## **Thorpe on the Hill Parish Council (PC) IP Ref: [REDACTED]**

### **Mitigation of the proposed FGE Solar Farm on the “Stepping Out” (SO) routes in Thorpe on the Hill**

Project No. : 60700987 Drawn: HW Checked: AM Approved: LB Date: 2025-08-22

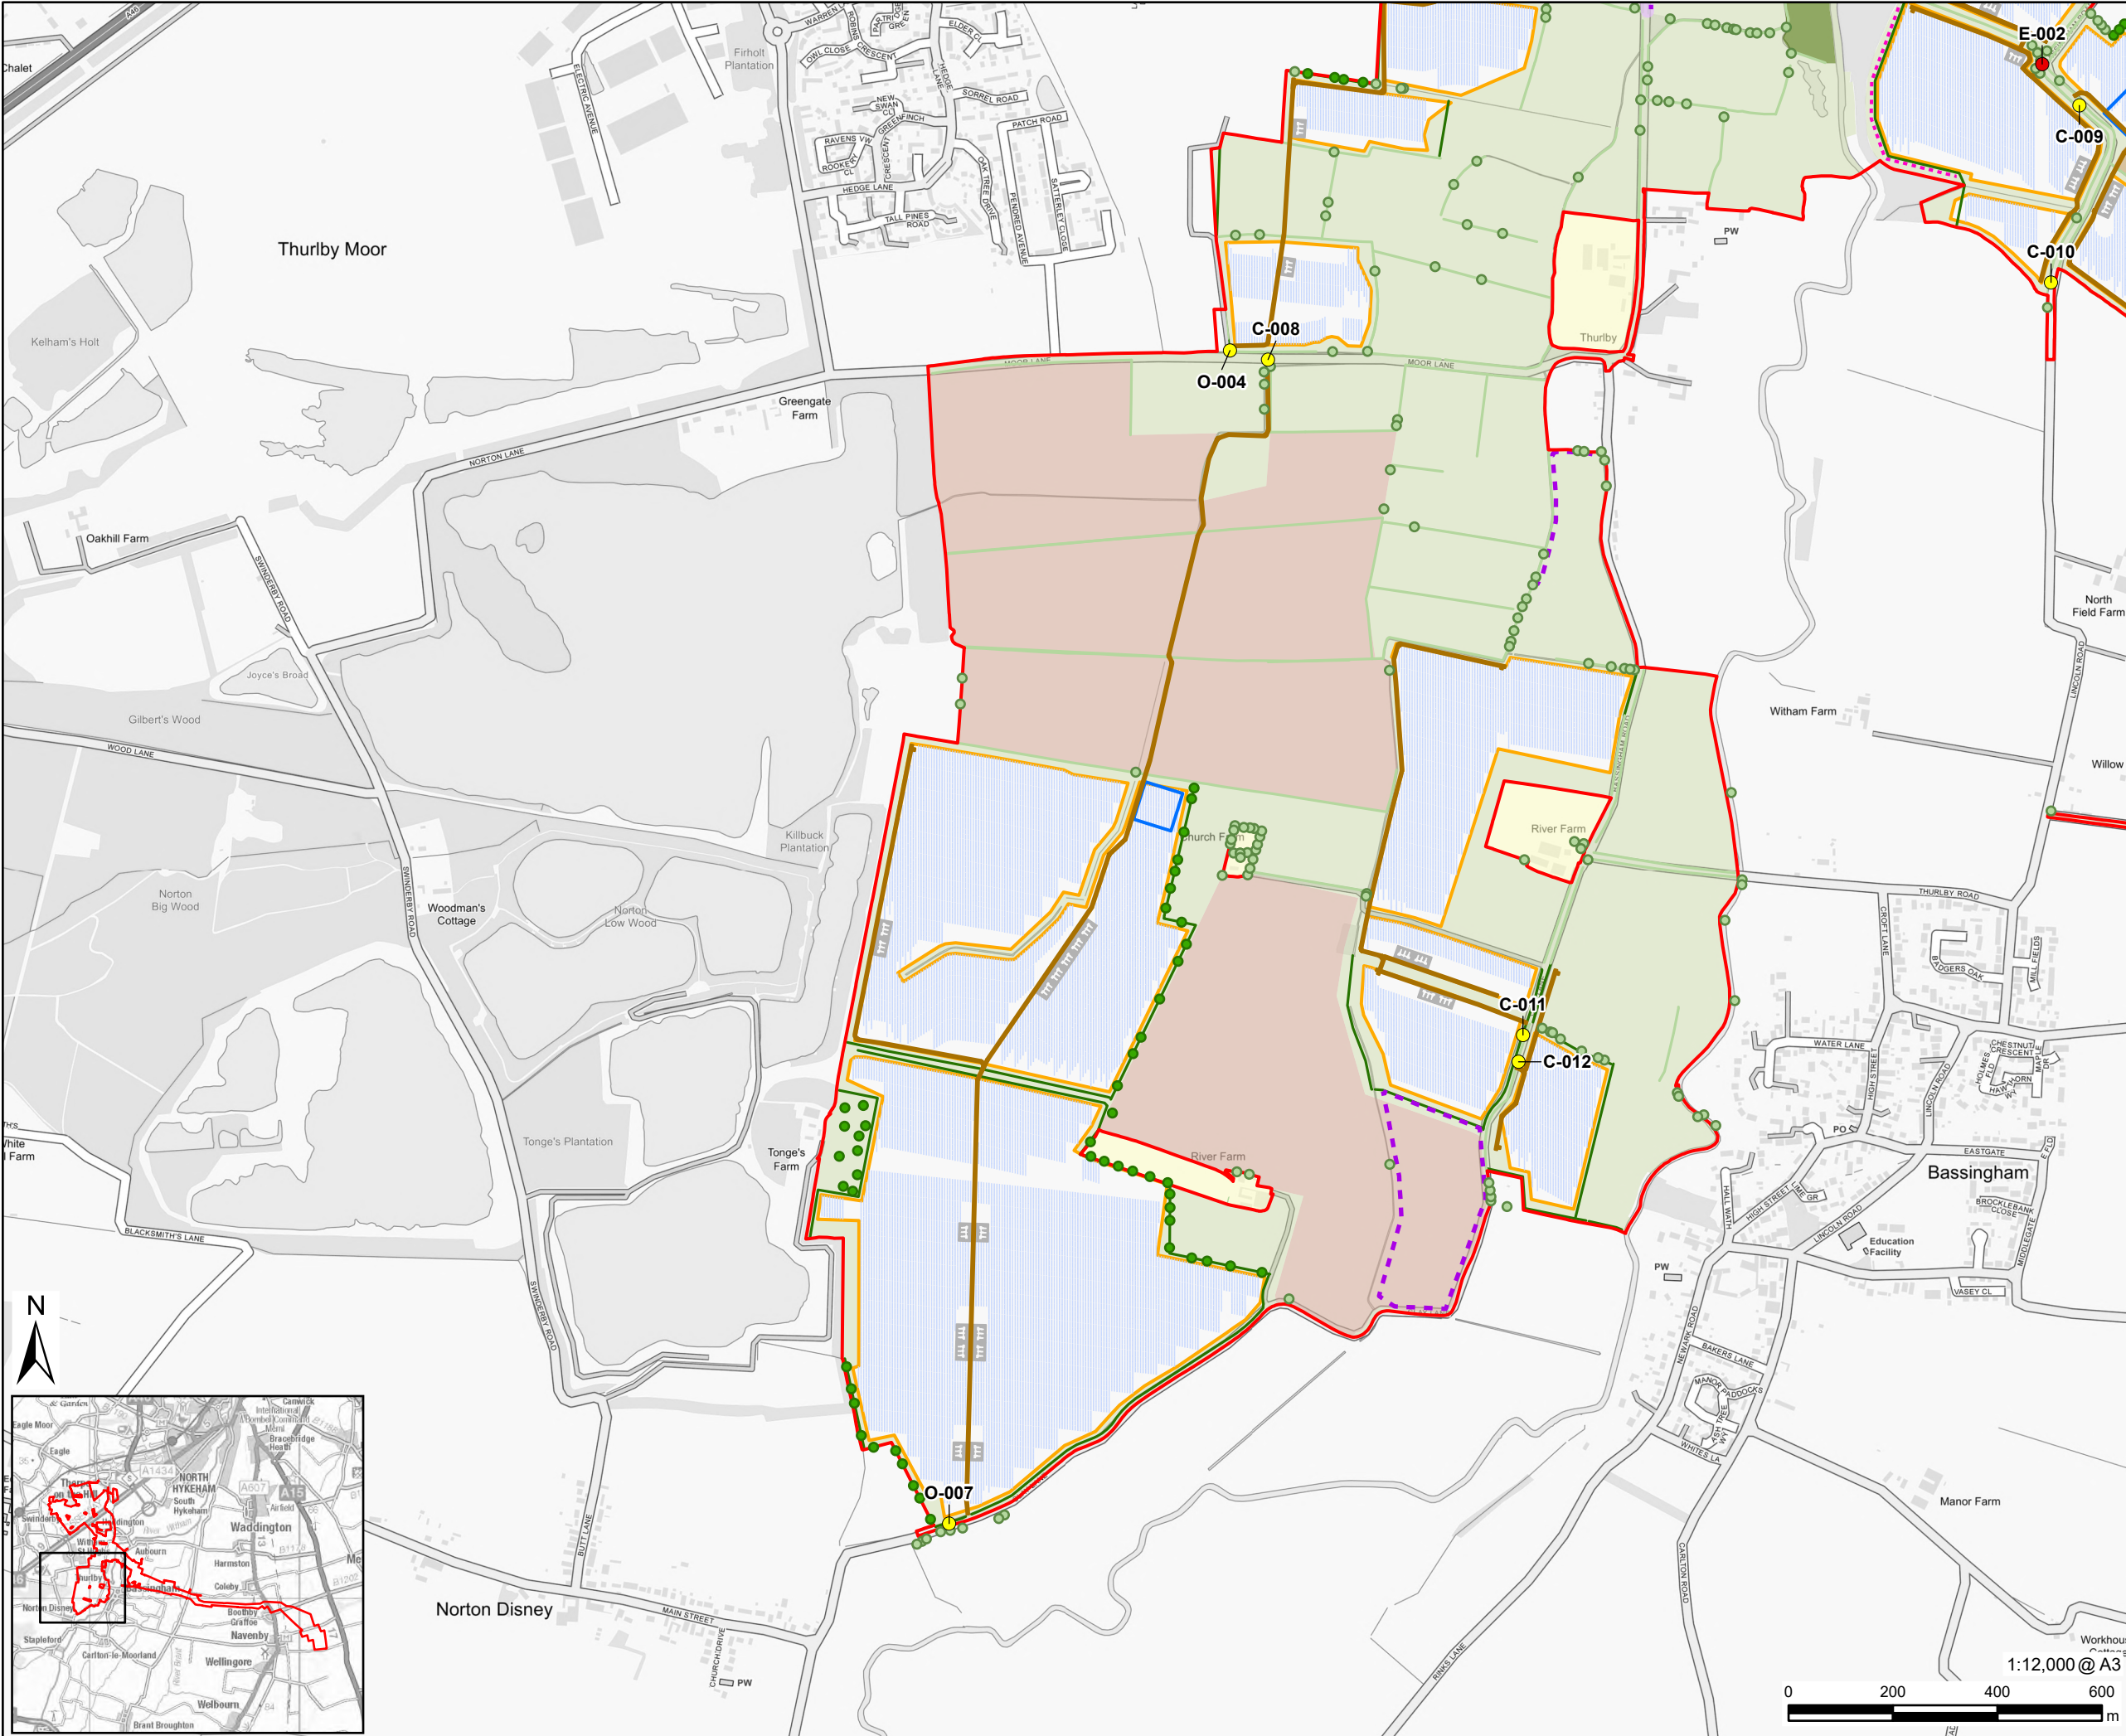
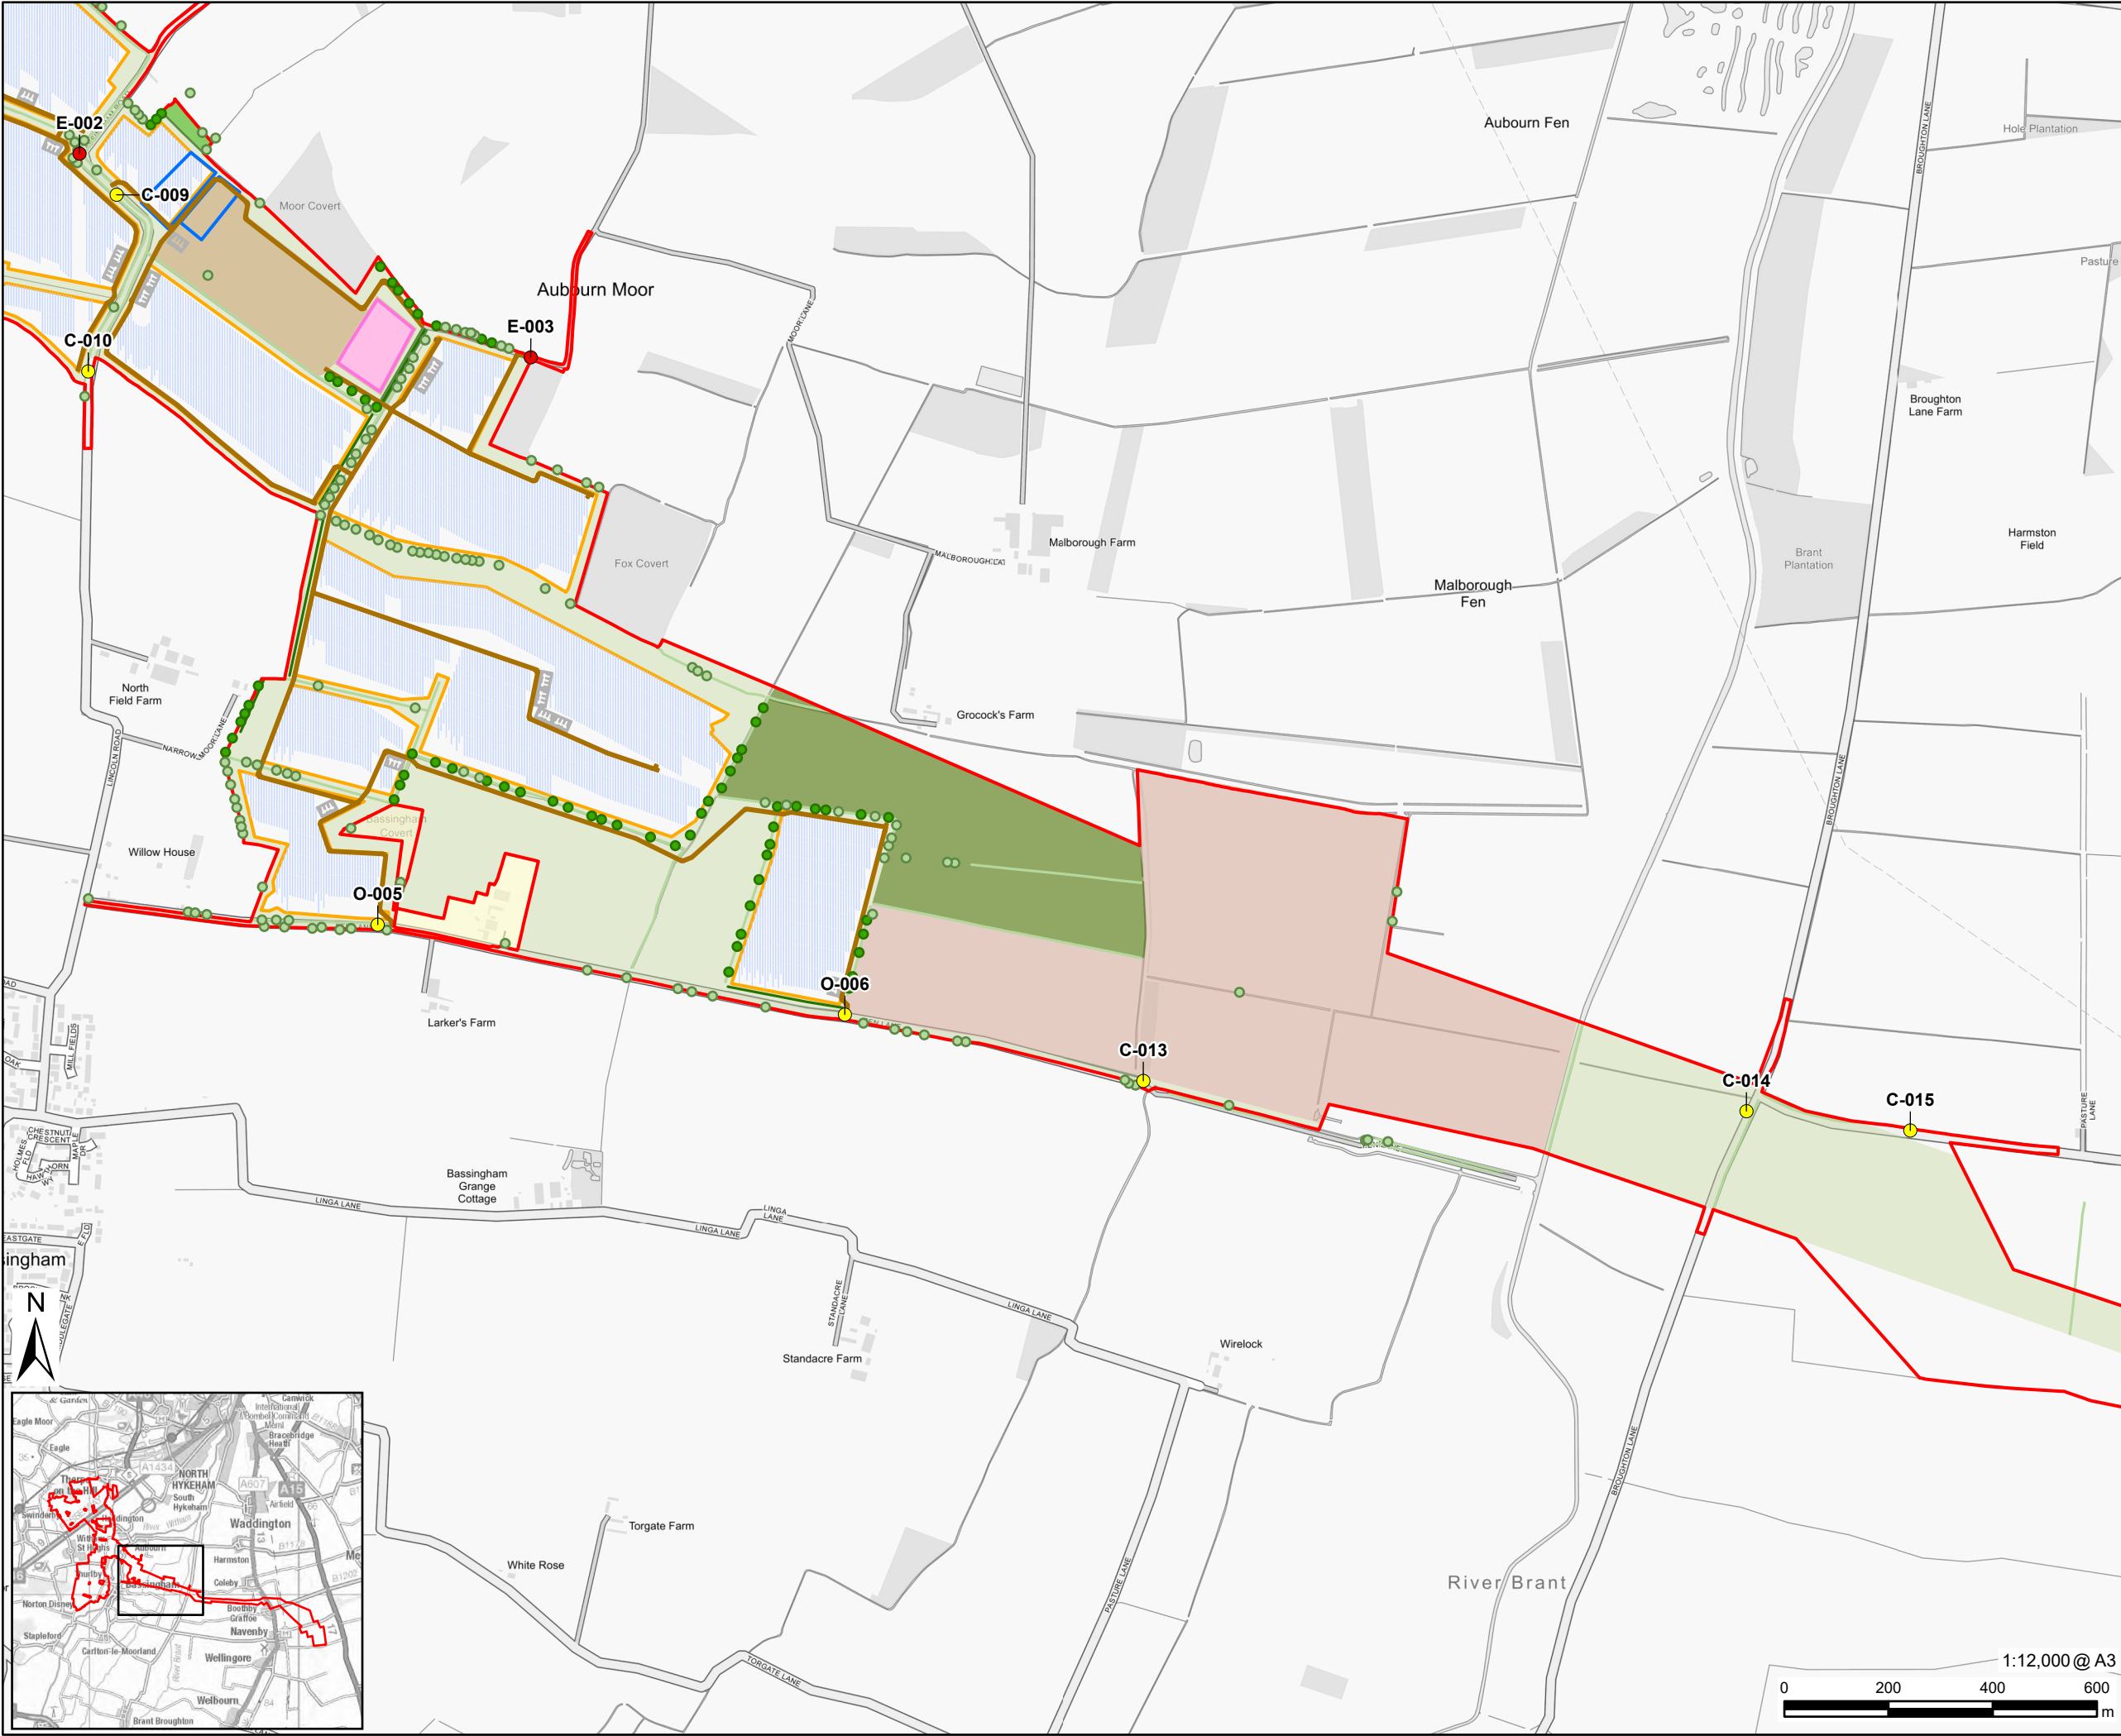
The PC does not believe that adequate consideration has been given to properly mitigating the potential effects of the proposed scheme on these routes. The following pages of this document contains reminders of the routes themselves which have been copied from the promotional leaflets. The diagram on page 4 is taken directly from the applicant’s documents FGE 2.2 Works Plans APP-008 EN010154 and shows the layout of solar arrays in the area surrounding the SO routes.

- Avoid any corridors where the SO routes would pass through solar arrays on both sides of the path creating tunnel effects. As a compromise solar arrays on one side of paths, where views are less important, are included
- Try to retain key views to Tunman Wood from the village and from Tunman Wood back to the village
- Try to retain key views identified in Thorpe on the Hill’s Neighbourhood plan
- Maintain, so far as is possible, open views which are characteristic of the locality rather than restrictive hedgerows which block key views
- Avoid changes which impact the integrity of the applicant’s proposal by requiring different access points or new parcels of land

Thorpe PC cannot claim professional planning expertise however, these simple revisions which are shown on page 5 appear very practical and do not require wholesale design changes to the applicant’s proposals. They would result in a reduction in area of solar arrays in the affected areas close to the SO routes but it might possible to recoup these elsewhere. If implemented, the PC believes they would enable many of the key features and benefits of the SO routes to be retained.
